Technical Note

Project No: ITB16481
Project Title: Land South of Summer Lane and West of Pagham Road, Pagham
Title: Highways Technical Note
Ref: TW/PL/ITB16481-004a
Date: 8 September 2022

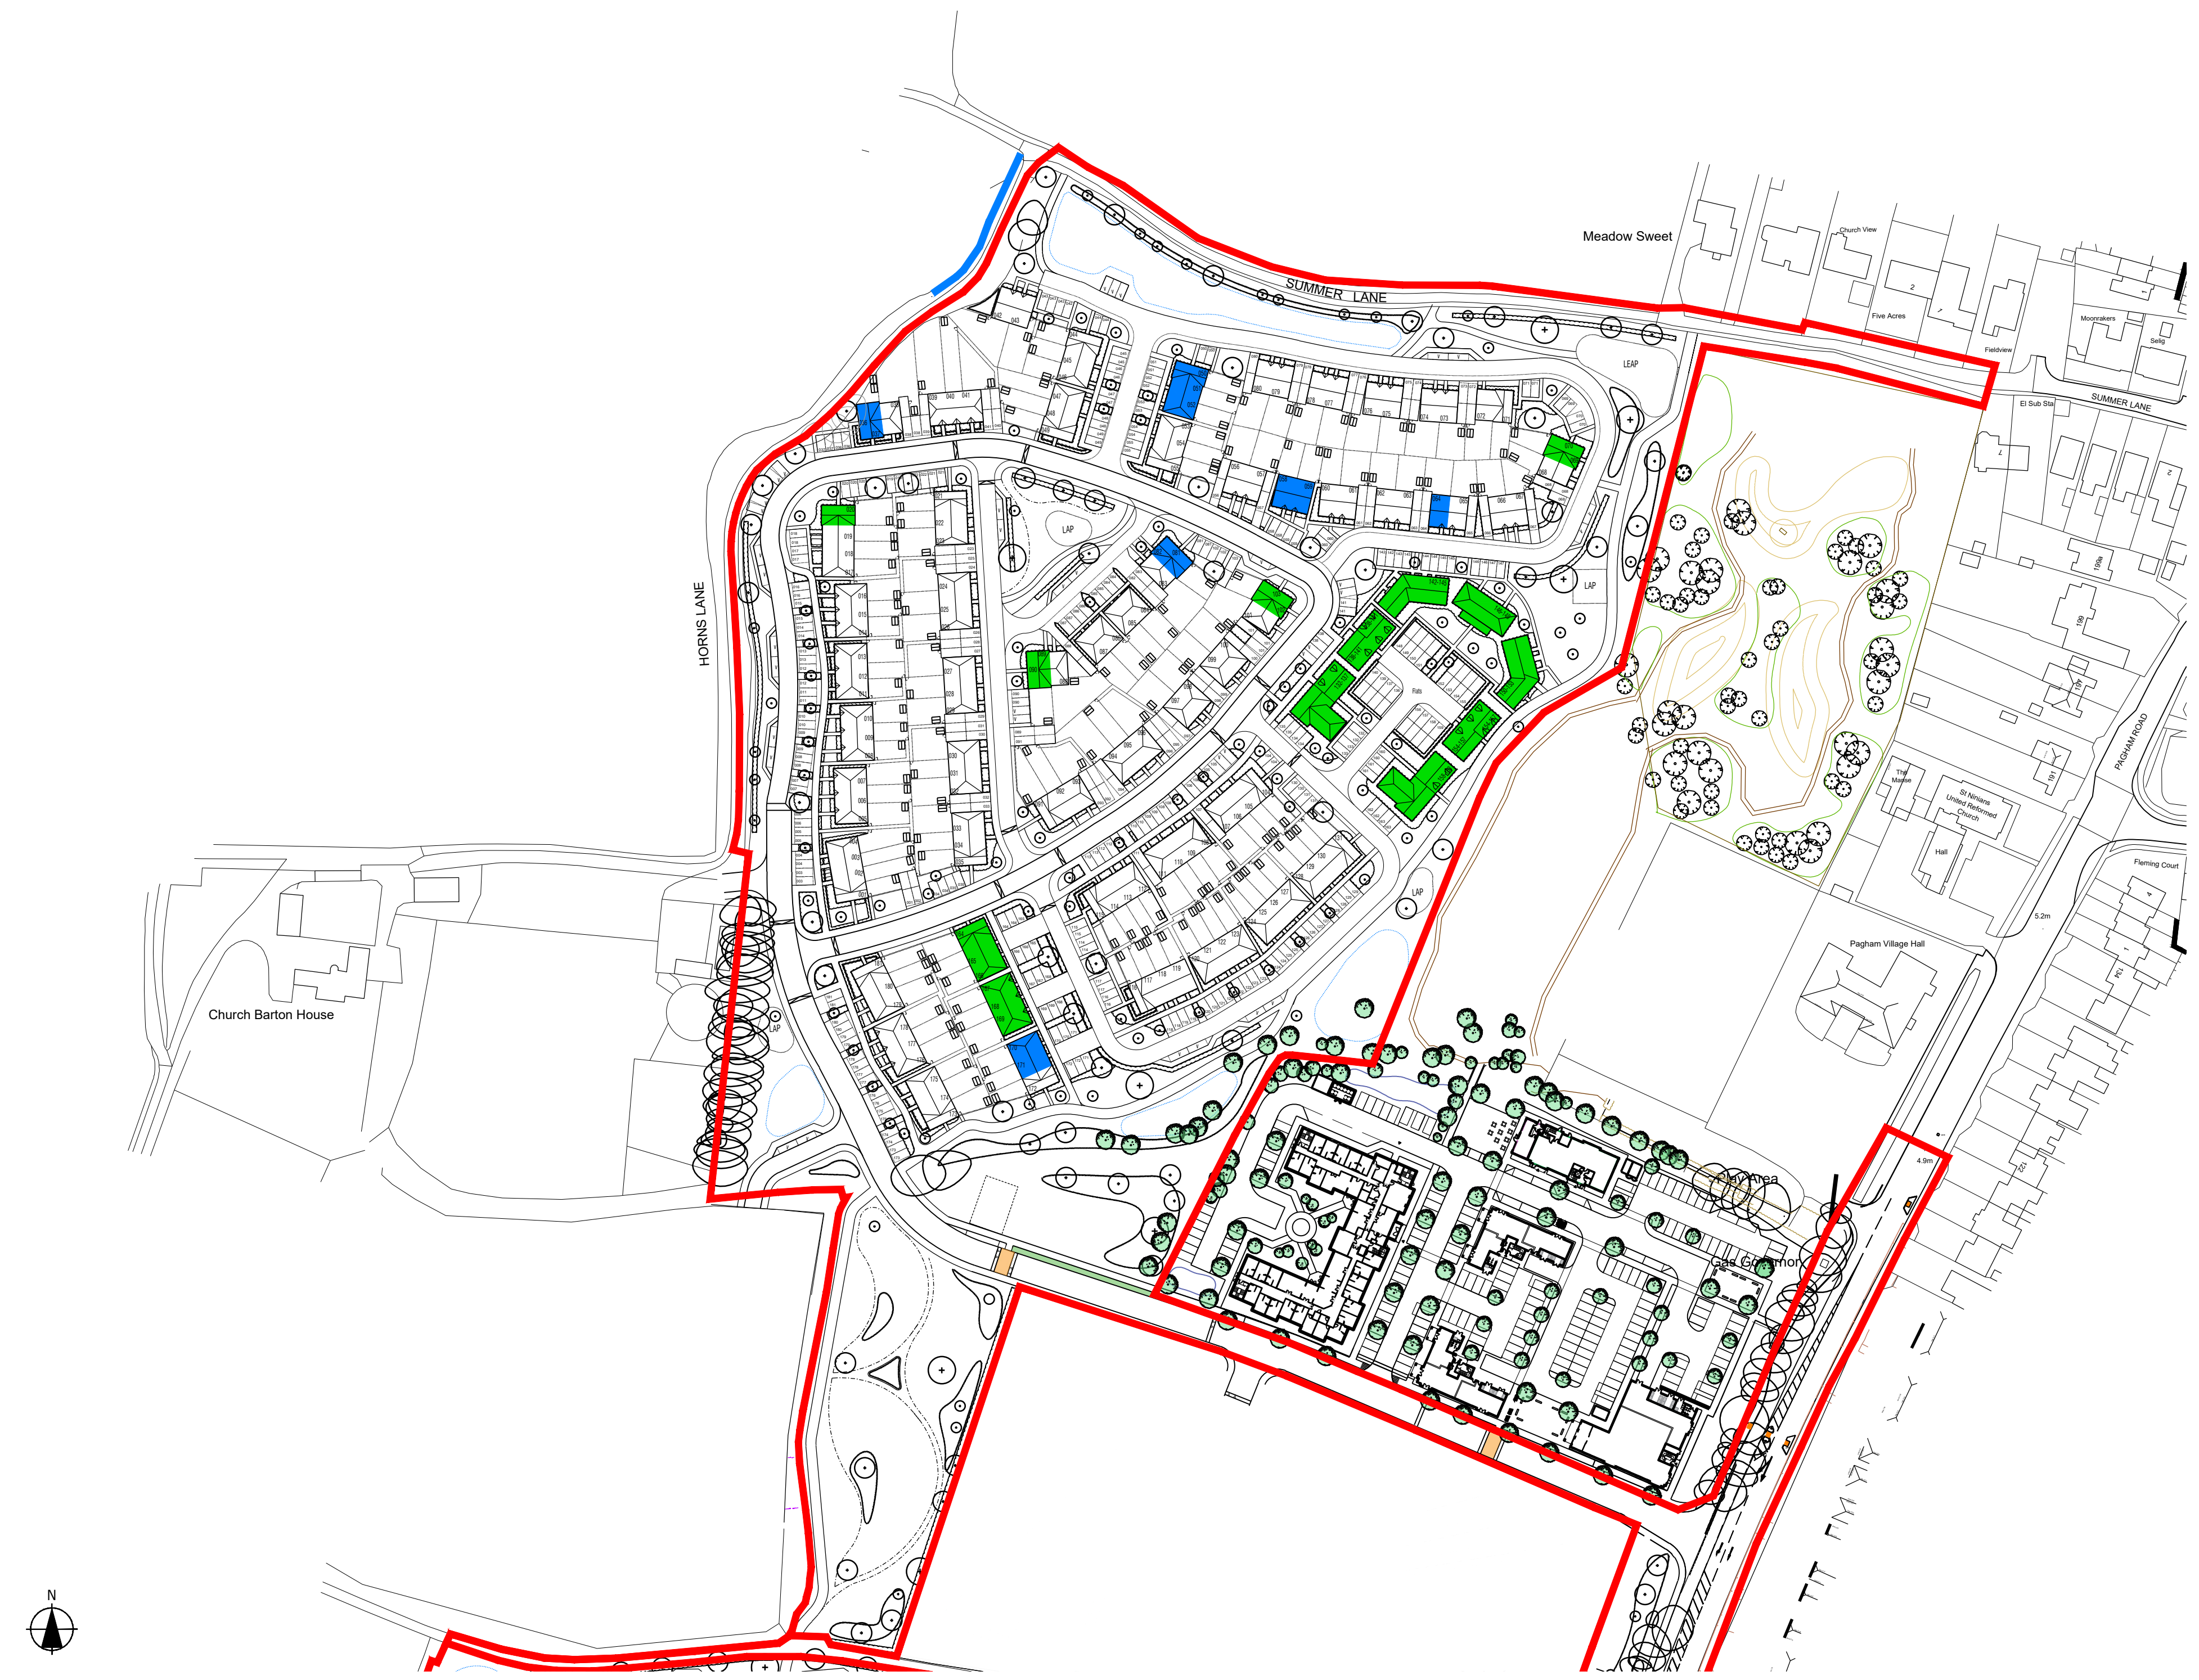
4. Raised concern with the width used for the road serving plots 253-258 and 267-270 given the number of dwellings served from this. Requested refuse vehicle tracking for this road and the road width to ideally be increased.	4. These two streets are Quaternary Streets. The Design Code sets out street widths for these as 3.7-4.8m. One of the streets is 4.8m, the other 4.1m, so these are in line with the Design Code and appropriate. WSCC confirmed this is acceptable. Tracking has been provided of the updated scheme in i-Transport Drawing ITB16481-GA-002 .

8. Given there is development on both sides of the secondary street serving plots 289-291/367-375 and 182-183/202-207, based on the Design Code, a footway should be provided across the frontages of plots 182-183 and 202-207 as well.	8. The footway connection across these plot frontages is provided and has been incorporated to the revised scheme.

9. Some of the raised features are at seemingly random locations (e.g. outside plot 244, 229 and 349) and some within shared surface areas. Raised features would be unnecessary within the shared surface areas. There is also an inconsistency in terms of how raised features are used at some but not all junctions. The overall use of raised features should be reviewed, and the layout amended accordingly.	9. Alterations to the various traffic calming features were agreed with WSCC. This has been implemented within the revised scheme layout.

10. The site plan includes a cycle route running from Pagham Road through the southern parcel and onward into the northern parcel to Summer Lane. It is recommended that the route is provided as a shared surface rather than segregated facility, which would require significantly more signing and lining.	10. The cycle route is part of the Approved Design Code (page 31). It will be provided as a shared surface path not a segregated route in line with WSCC requests.

12. The need of for the new southern pedestrian access is perhaps questionable. The applicant would also need to consider and provide further pedestrian crossing infrastructure.	12. The connection at plot 344 was part of the Outline permission and provides a direct access to the bus stop. The southern connection is new, but WSCC has since then confirmed no objections in principle to this being created, which will improve permeability. Crossing facilities would comprise a dropped kerb and tactile paving as illustrated in Drawing ITB16481-GA-007 .
